KITITAS COUNTY

MEMORANDUM

TO: All Staff
FROM: Justin Turnbull, County Surveyor 
DATE: August 4, 2021
SUBJECT: 2nd County Survey Review of SPF-21-00005 Zipperer

**ZIPPERER SHORT PLAT, SP-20-00005
 SPF-21-00002**

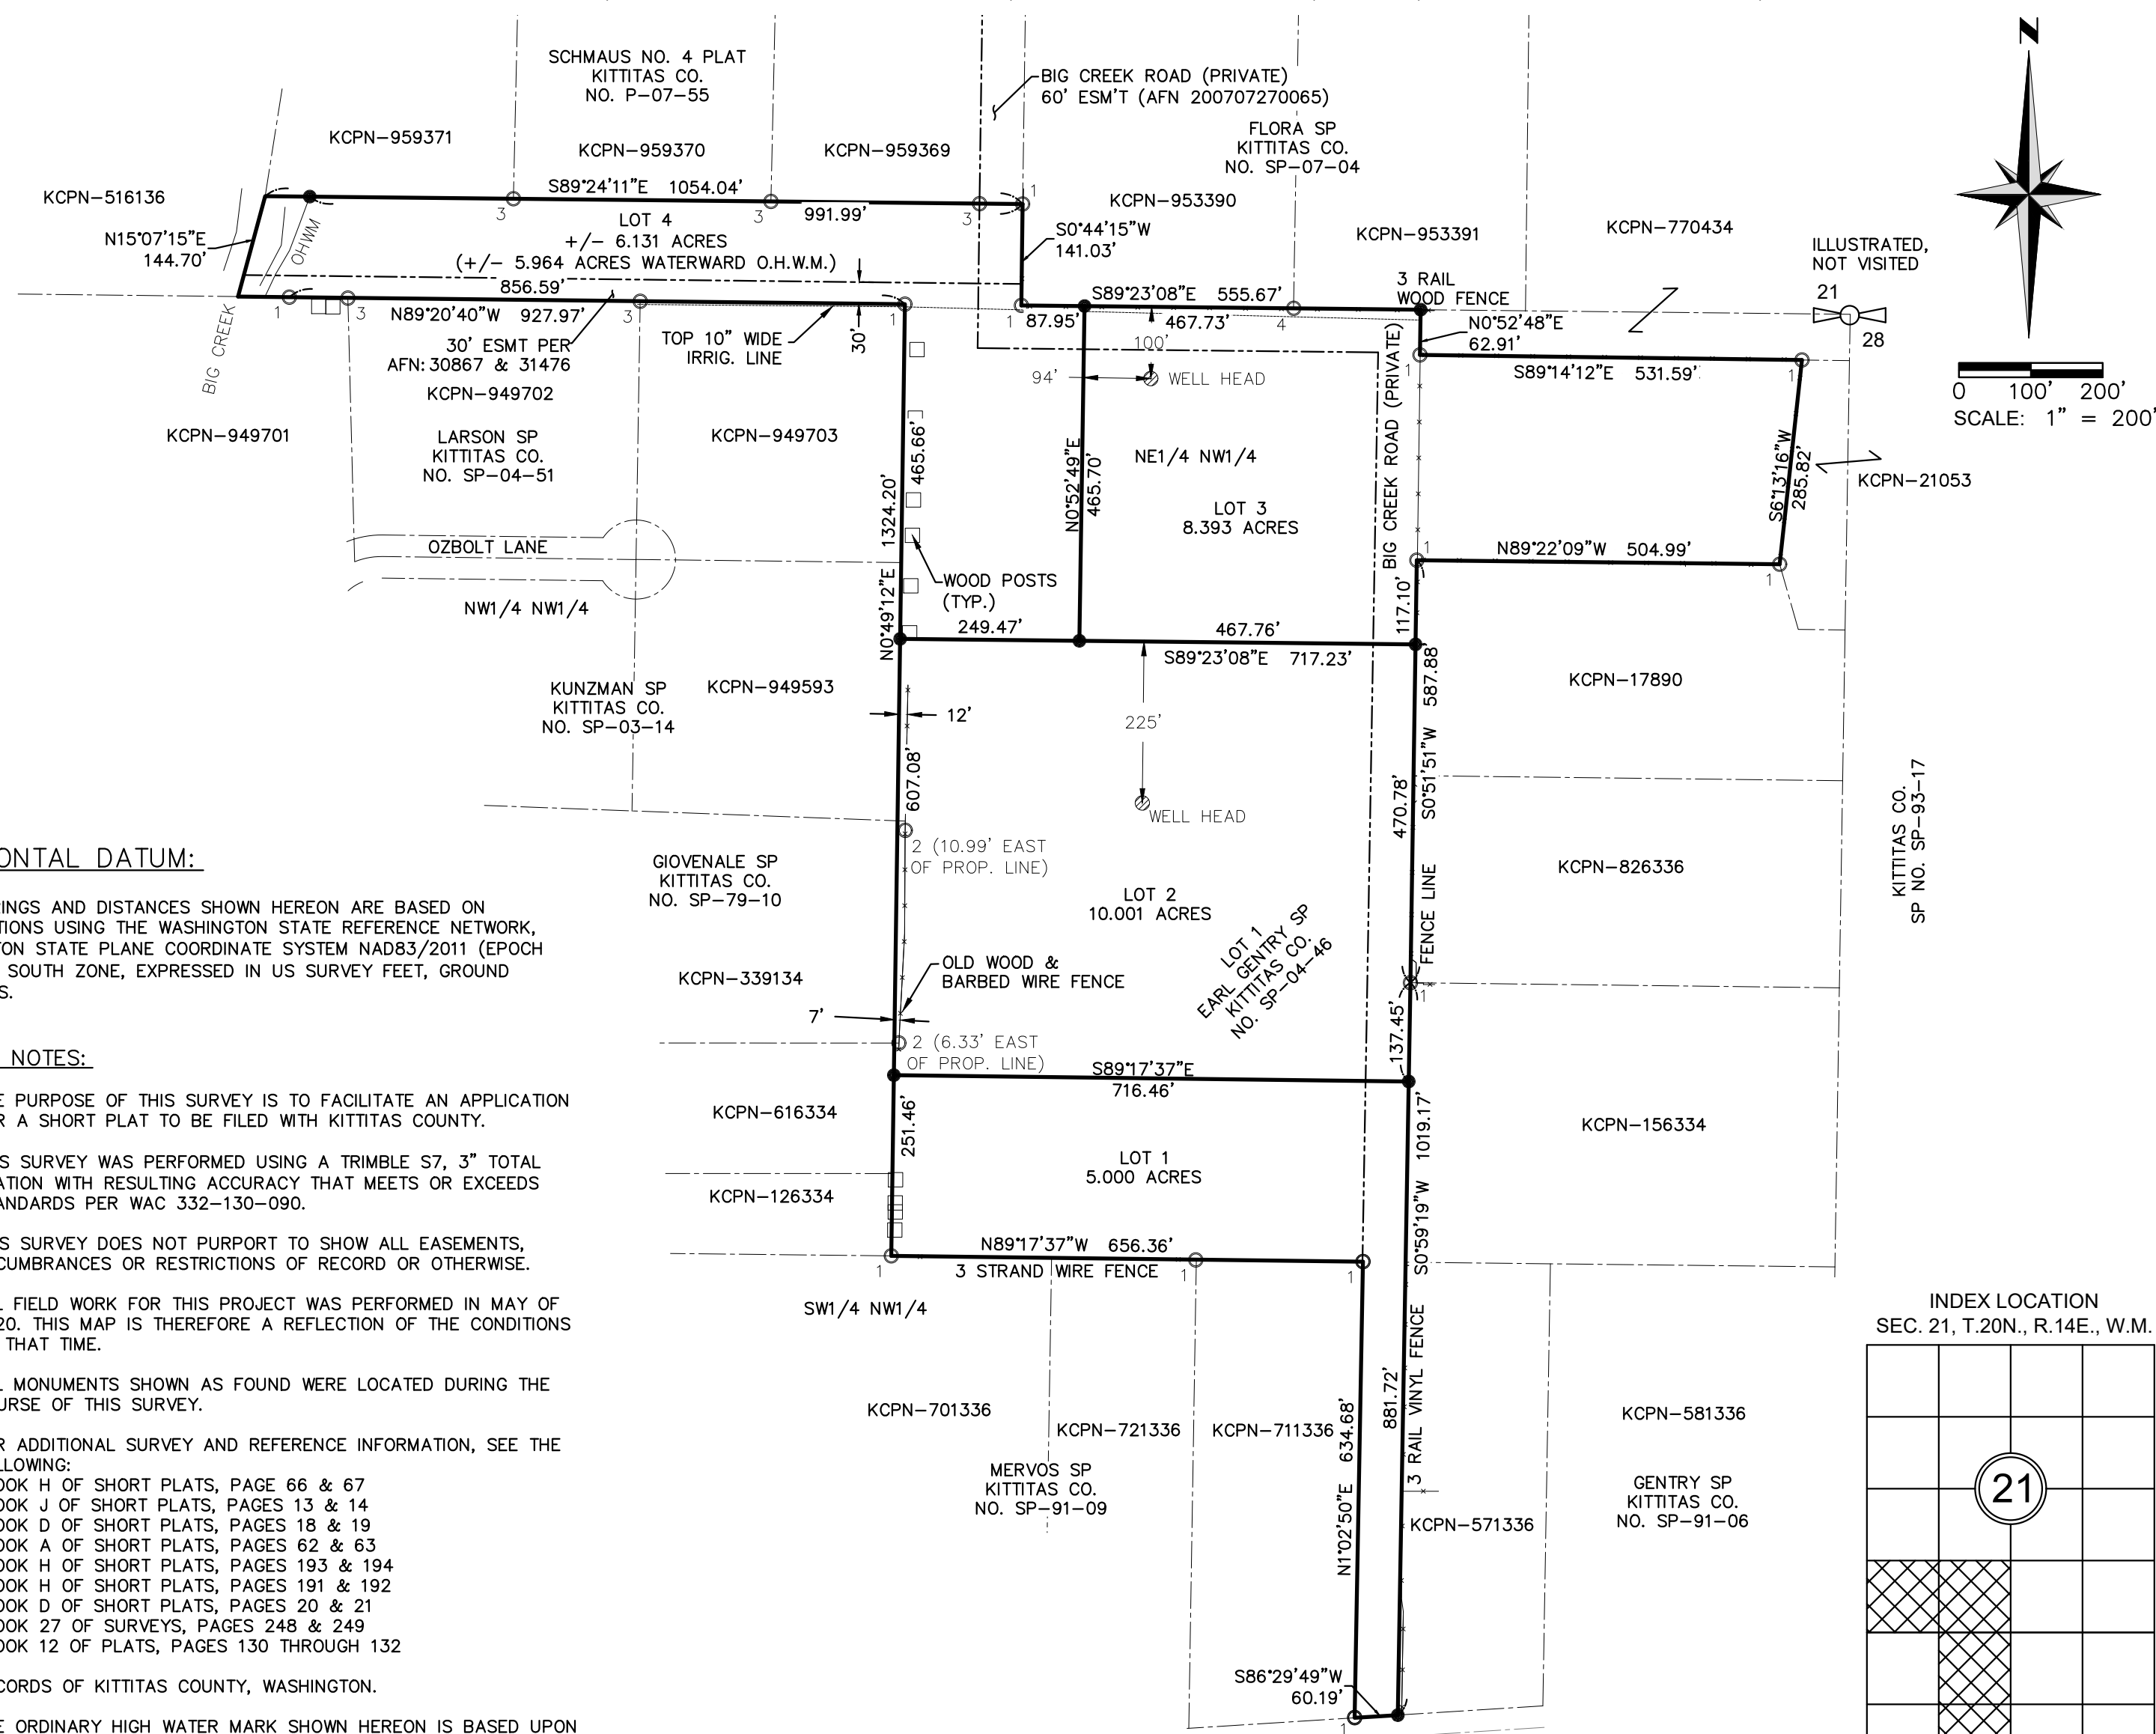
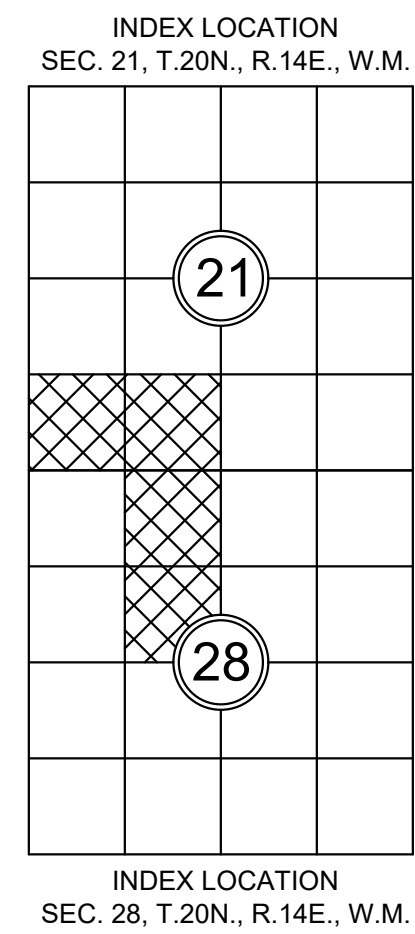
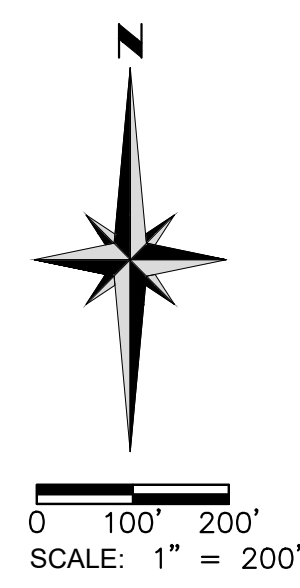
1. The basis of bearing has not been addressed. While an argument could be made for the Horizontal Datum statement qualifying as a basis of bearing, it essentially accepts ALL bearings shown as being equal in value... which goes against the intent of having a Basis of Bearing.

Other areas in the world completely accept coordinate-based basis (Canada), while others will only accept found monuments of record (California). Washington is explicit that Basis of Bearings must be addressed..... while noting that "Basis of Bearing: None" is completely acceptable.

Please include a Basis of Bearing statement (or identify the line held as such) on the face of your Short Plat.
